Report of the Interim Director of Planning, Regeneration & Public Realm

Address BRIDGE HOUSE, 1A BRIDGE WAY ICKENHAM

Development: Erection of single storey side extension (Application for a Certificate of Lawful Development for a Proposed Development)

LBH Ref Nos: 43797/APP/2022/1764

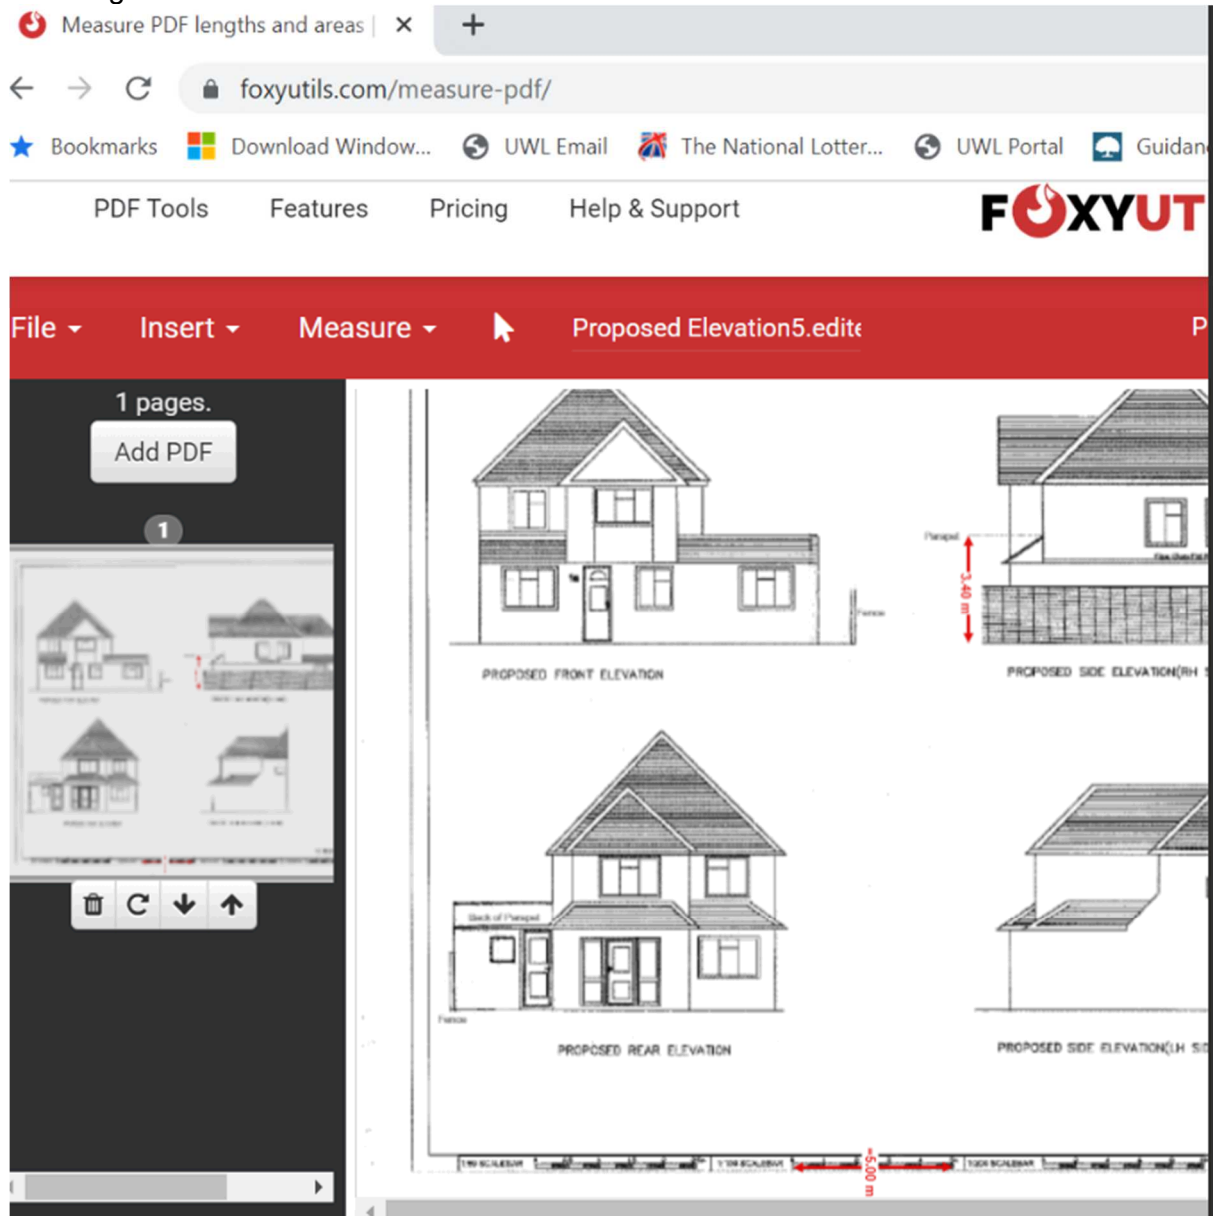
The proposed development does not constitute permitted development by virtue of the provisions of paragraph A.1(e)(ii), Class A, Part 1, Schedule 2, Article 3 of the Town and Country Planning (General Permitted Development) (England) Order 2015 (as amended) because the proposed single storey side extension would extend beyond a wall which fronts a highway and forms a side elevation of the original dwellinghouse.

YES- The proposed single storey side extension would extend beyond a wall which fronts a highway and forms a side elevation of the original dwellinghouse.
